PAINT BRUSH HILLS FILING 14 ZONE CHANGE MAP

PROJECT:
PAINT BRUSH HILLS FIL. NO 14

ZONE MAP

PCD FILE NO.: P185

# PAINT BRUSH HILLS FILING 14 ZONE CHANGE MAP

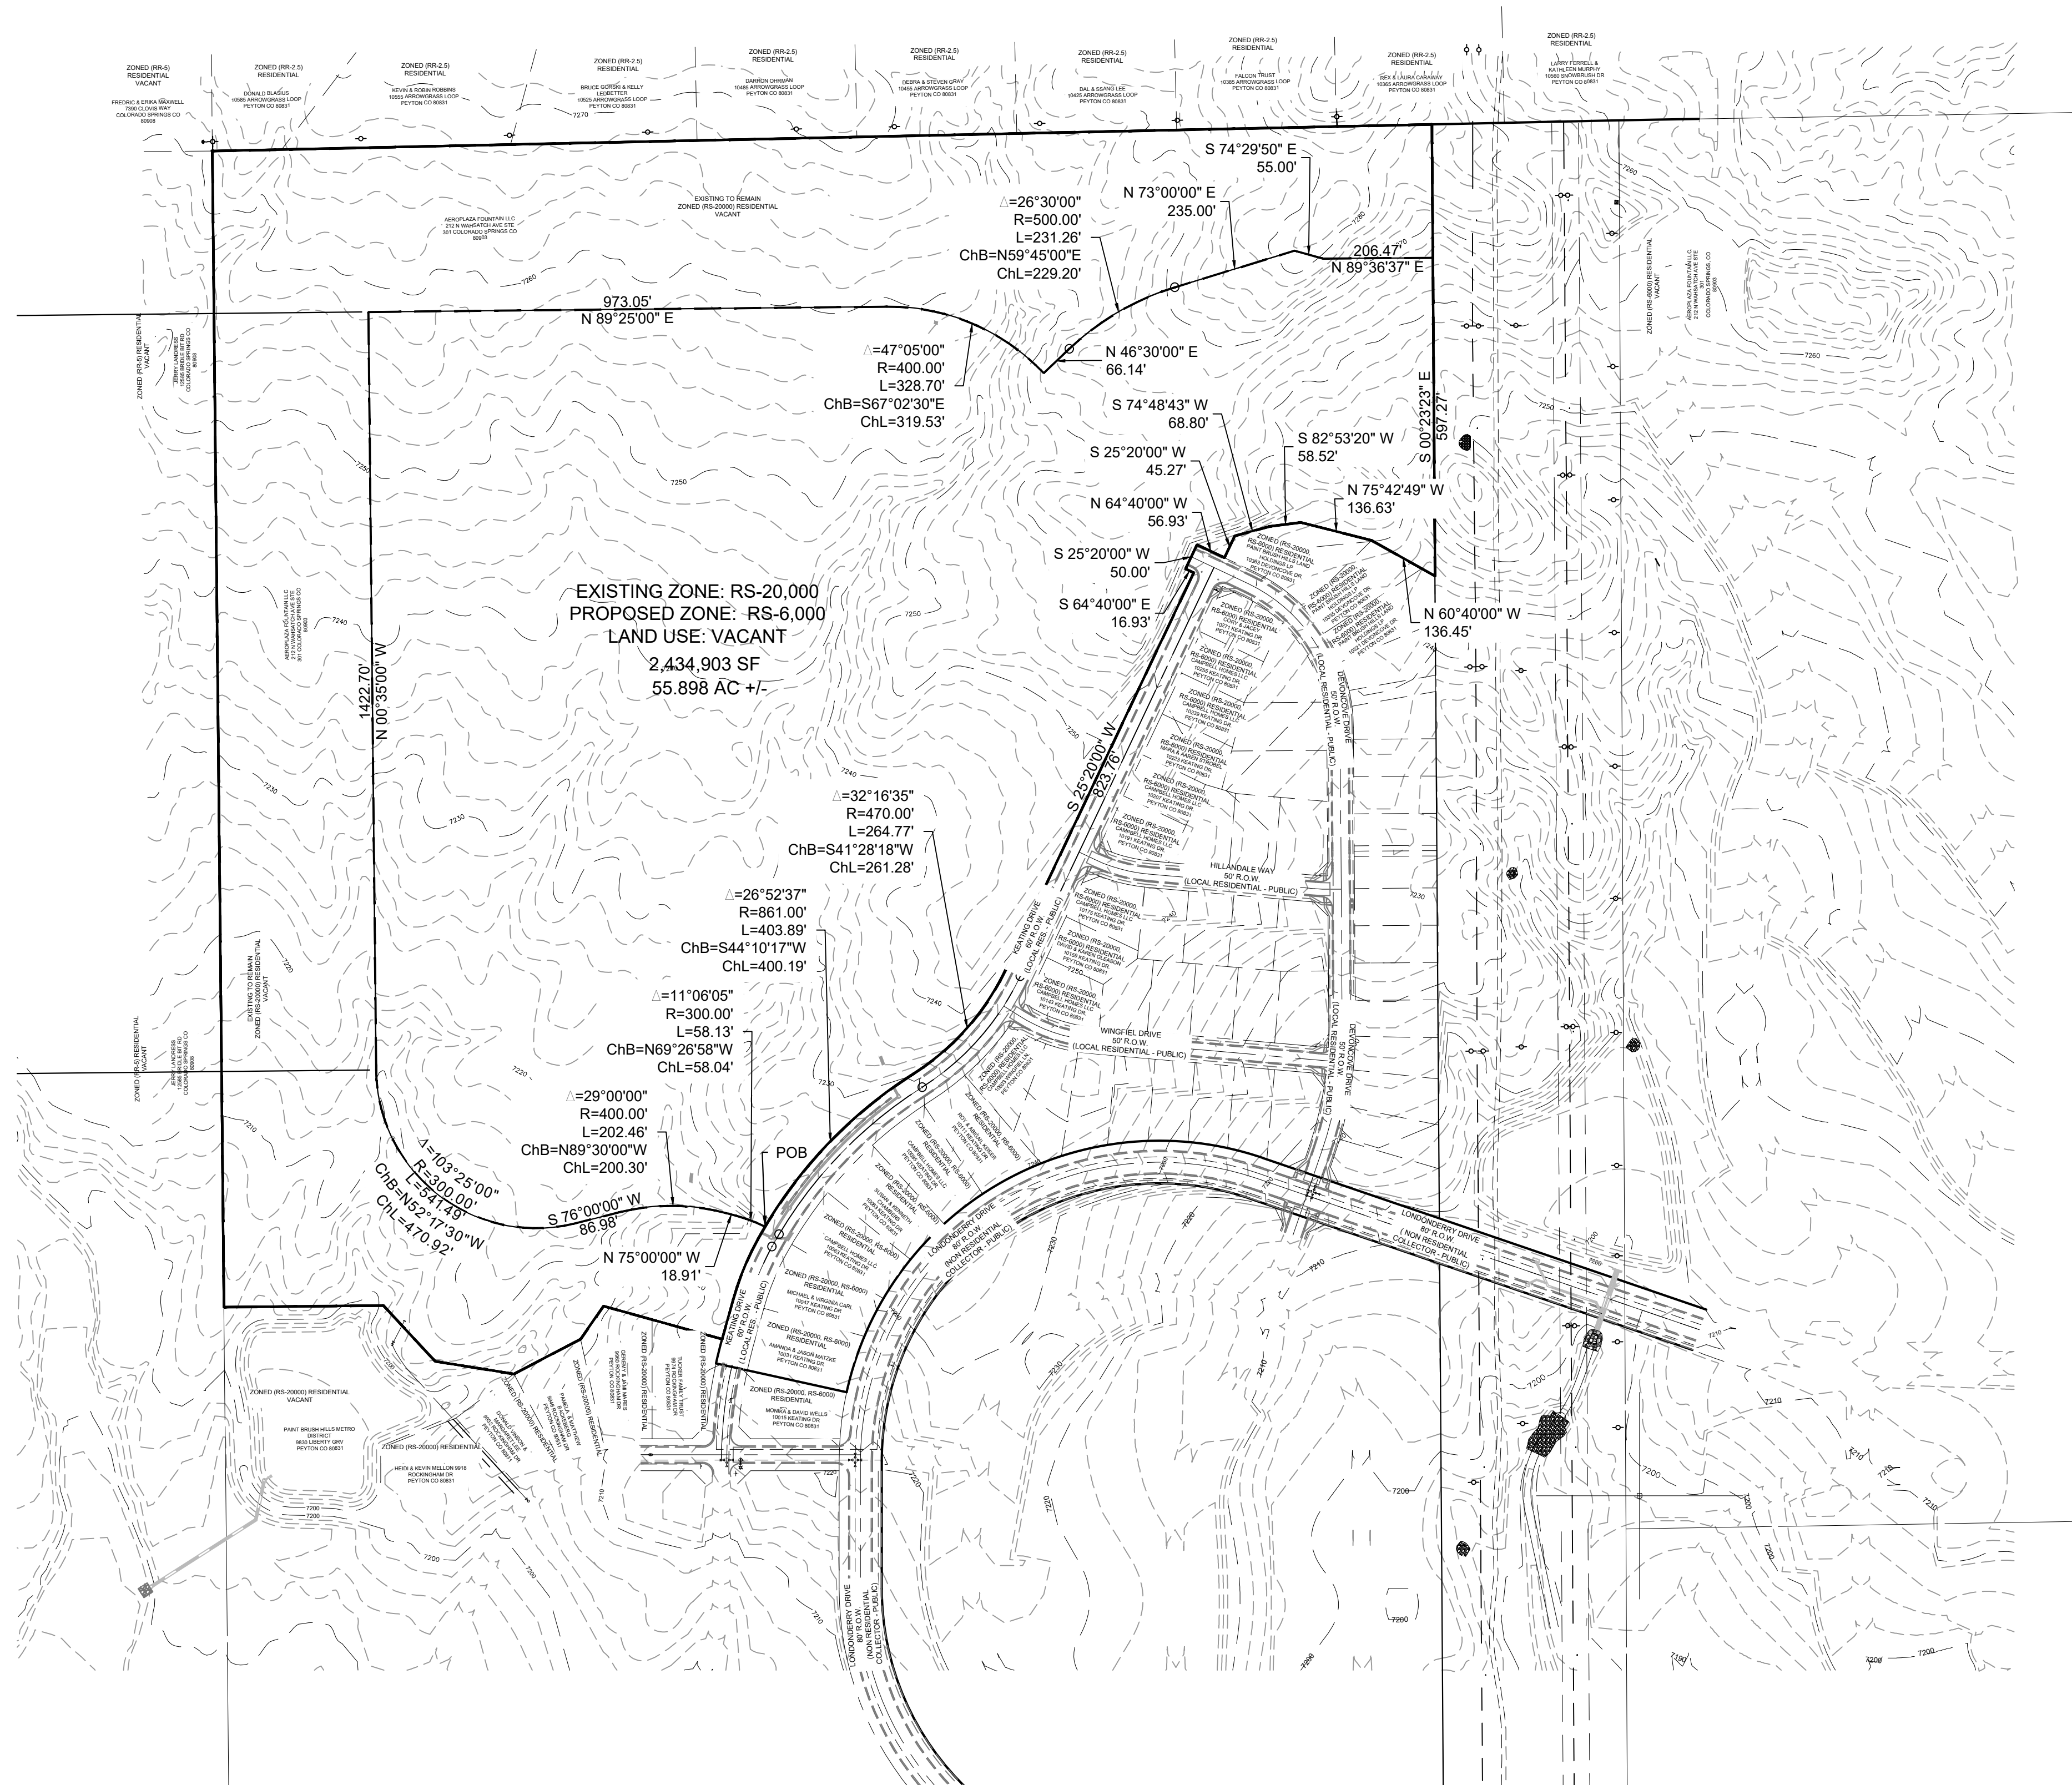
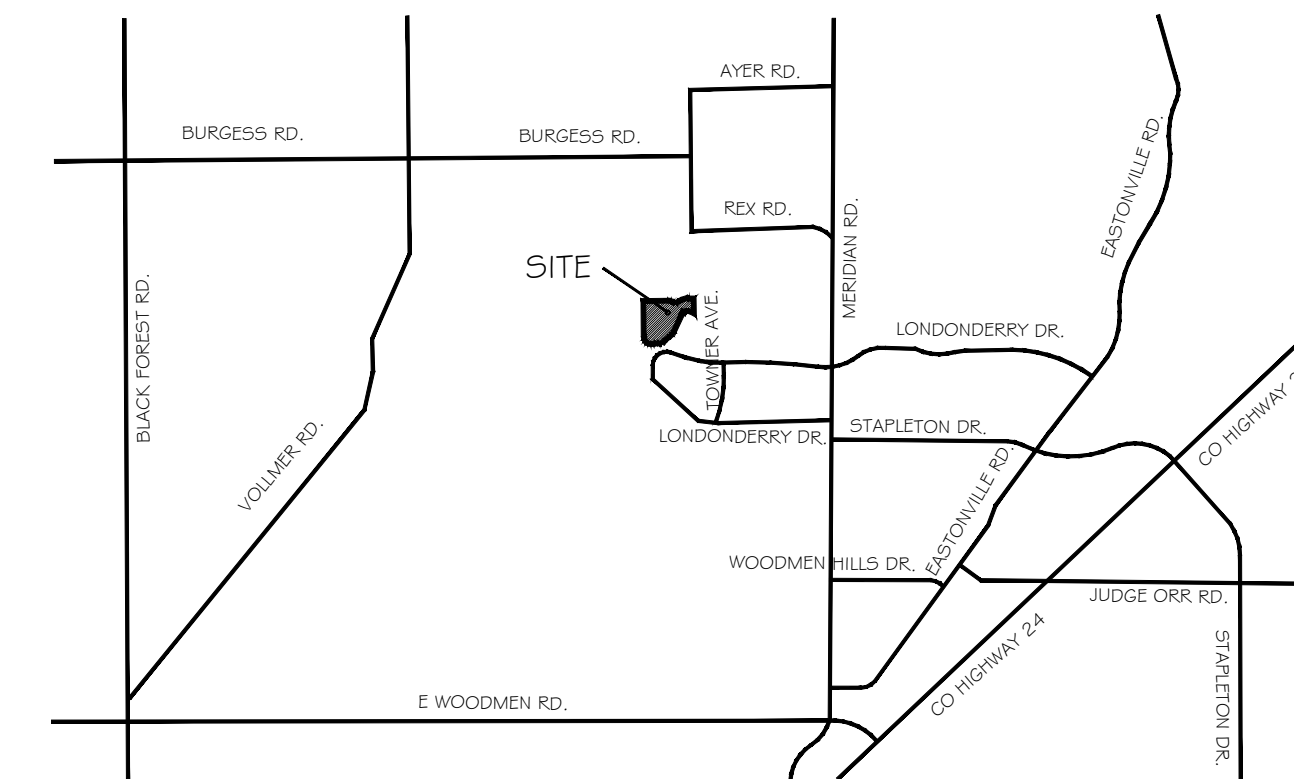
Repeat comment: Please show the platted ROW and stub out here.
